**A57 Link Roads**

**TR010034**

**9.88 Applicant's comments on Deadline 11  
submissions**

May 2022

Drawing Number	HE551473 - BBA - EGN - A57_AL_SCHEME - DR - LE - 060414
Location	Location
Scale	1:5,000
Original Size	A3
Rev	P01

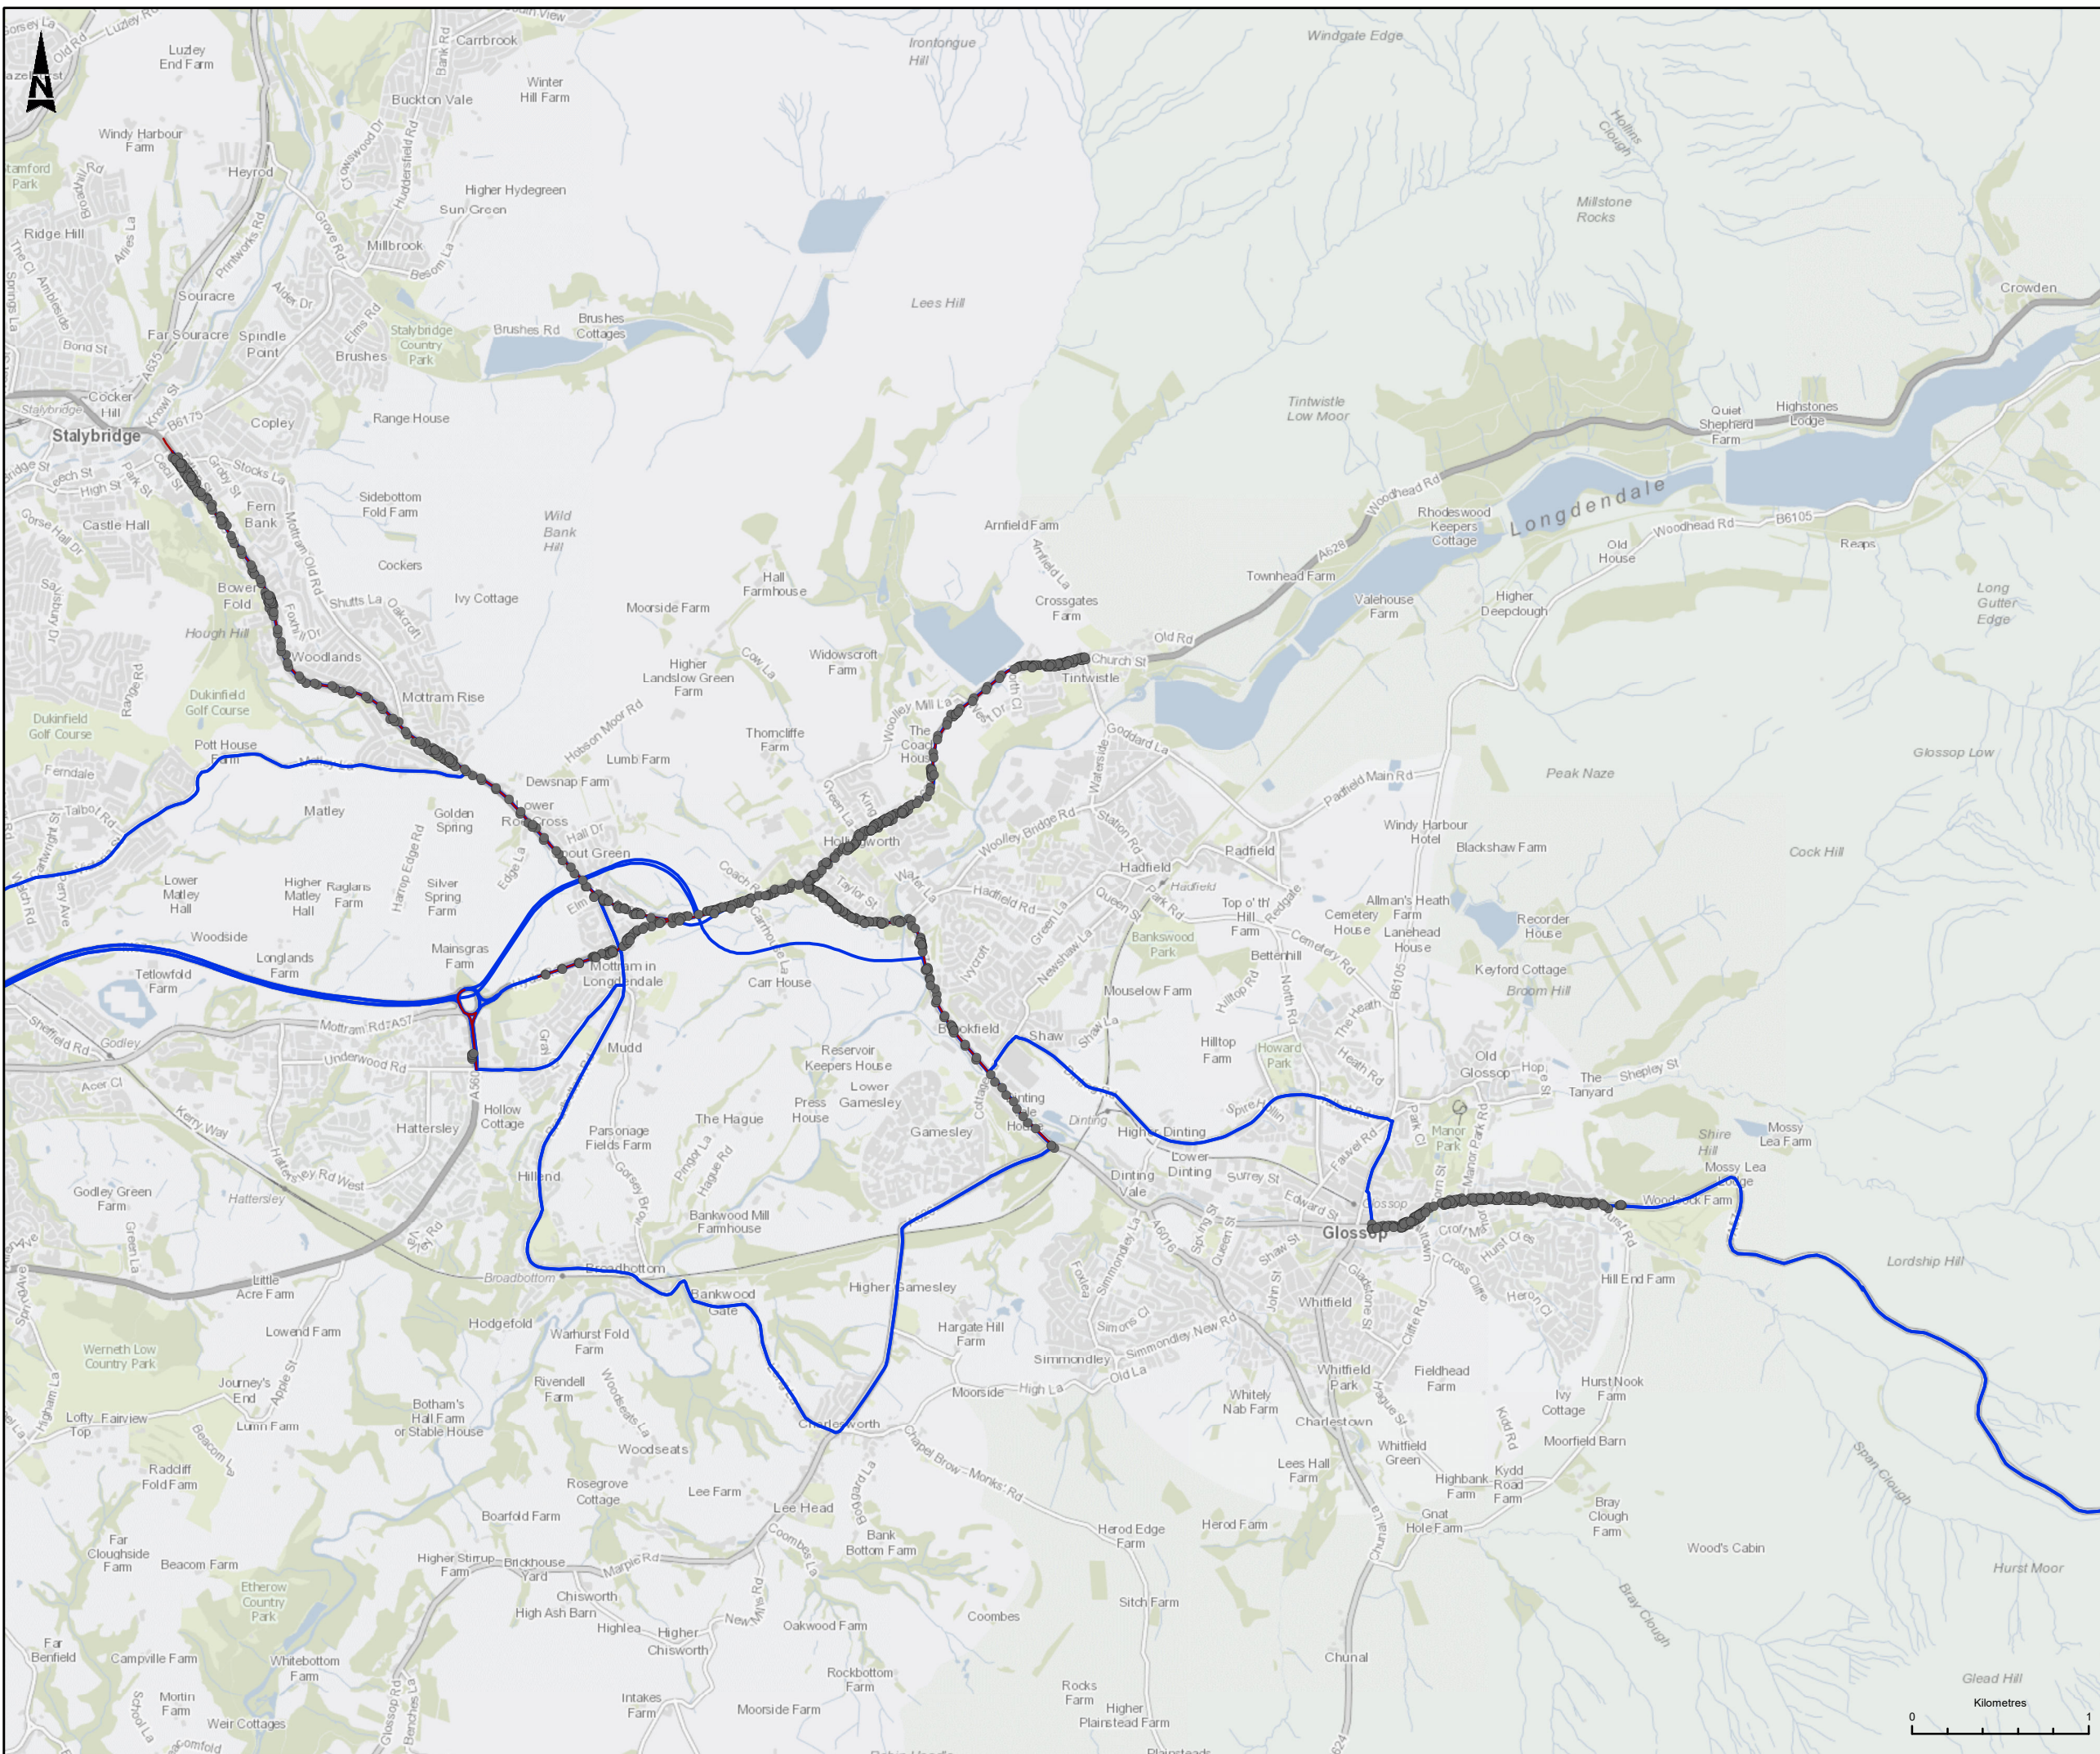
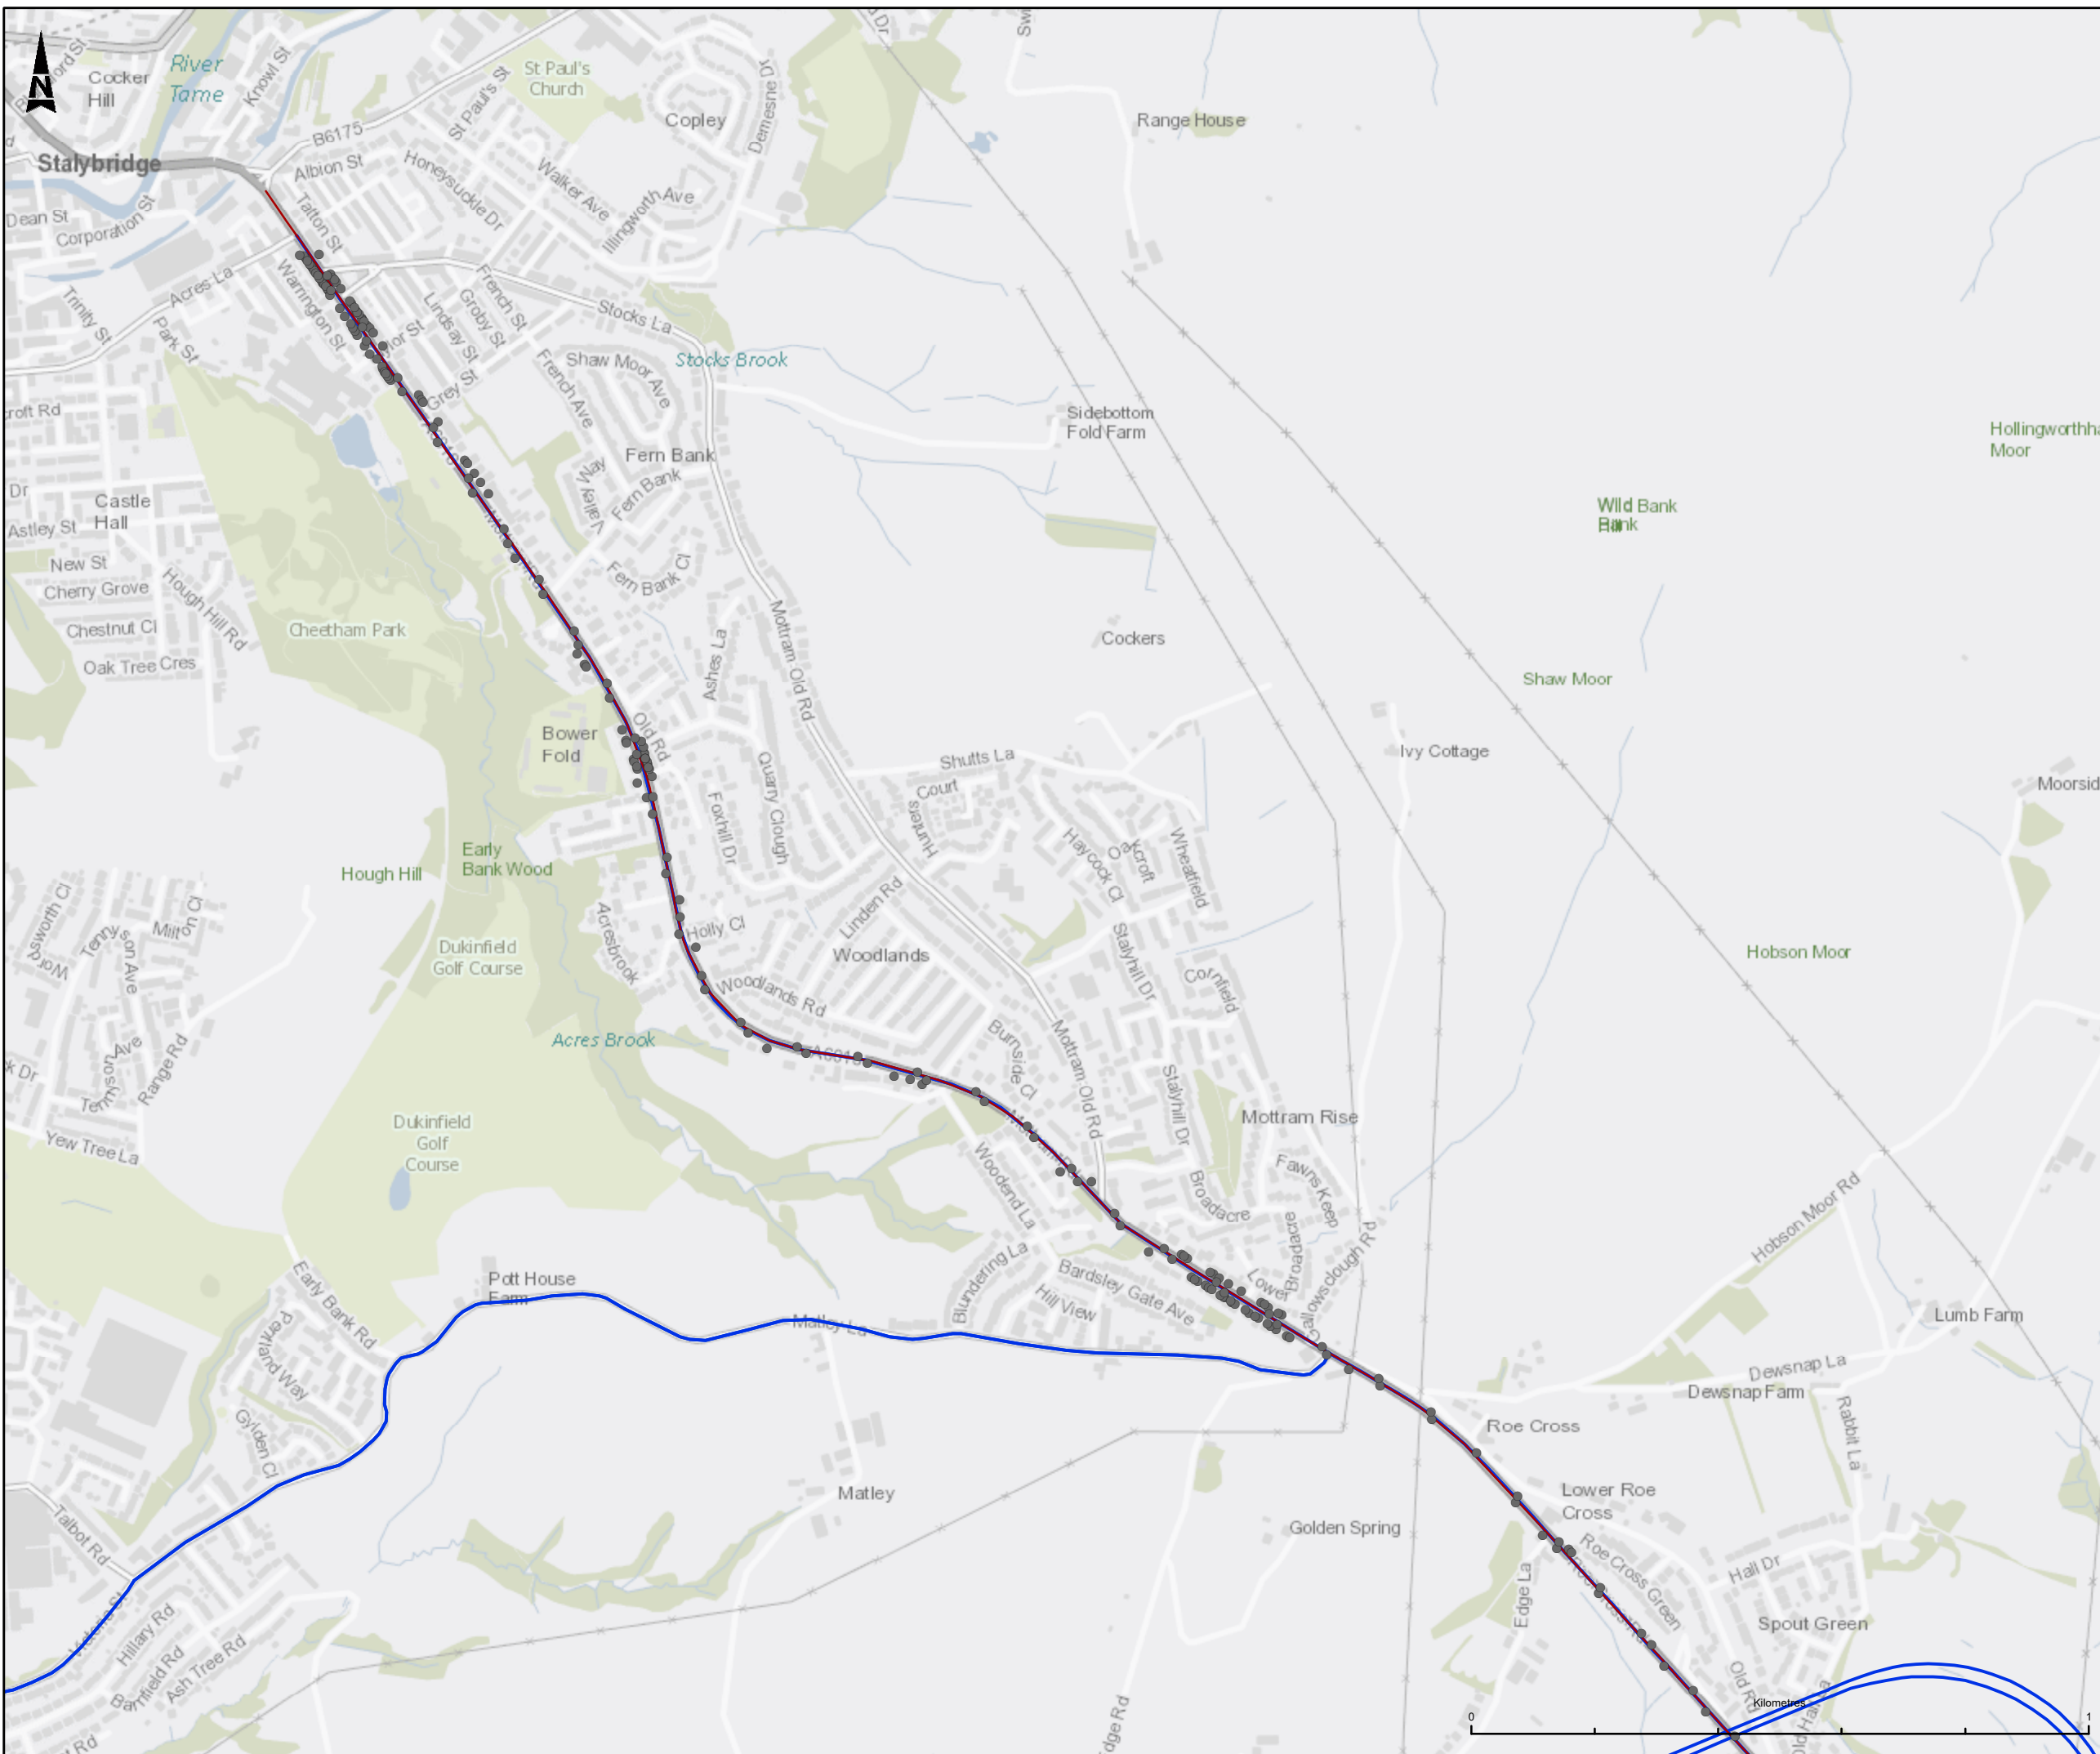
Reference	IP Issue	NH Response
9.88.4	<ul style="list-style-type: none"> <li>human health receptors on the A57 in Brookfield Identification of the receptors (figure 5.4) used in the compliance risk assessment (using LAQM “conservative” forecast”) indicated that “large” change at some of the receptors along Brookfield. However, it also highlighted that some of these were human health receptors that had not been included as receptors in the (less conservative) primary human health AQ assessment (DMRB LA 105). Therefore, HPBC have requested that these receptors are also assessed in accordance with the DMRB LA 105 . Following further discussion and clarification (virtual meeting held 8th April 2022) it was agreed that a sensitivity test will be undertaken to identify the air quality impact at relevant qualifying feature receptors located adjacent to the A57 Brookfield under the DMRB LA 105 human health assessment methodology (to be submitted by National Highways at deadline 11 – ref. TR010034/EXAM/9.86) Results from the updated air quality assessment updated DMRB LA 105 indicated a “Large increase” in NO2 DS compared to DM in 2025, at locations along Wooley Bridge with 1 location exceeding the AQO (40ug/m3) as a result of the scheme.</li> </ul>	<p>The Applicant’s position is provided in the Deadline 12 submission of the final Statement of Common Ground with High Peak Borough Council (TR010034/APP/8.3(3)). The supplementary air quality assessment for Brookfield is provided in REP11-011. It states that, [for receptors exceeding air quality standards] given the number of receptors (75 receptors) that experience a decrease in concentrations with the Scheme, it is still considered that this outweighs the one receptor with a ‘small’ increase in concentration and one receptor with a ‘large’ increase in concentration with the Scheme. Overall, as reported in the ES, the impact of the Scheme is an improvement in air quality for human health receptors and there is not a significant adverse effect due to the Scheme (paragraph 6.1.2 of REP11-011).</p>
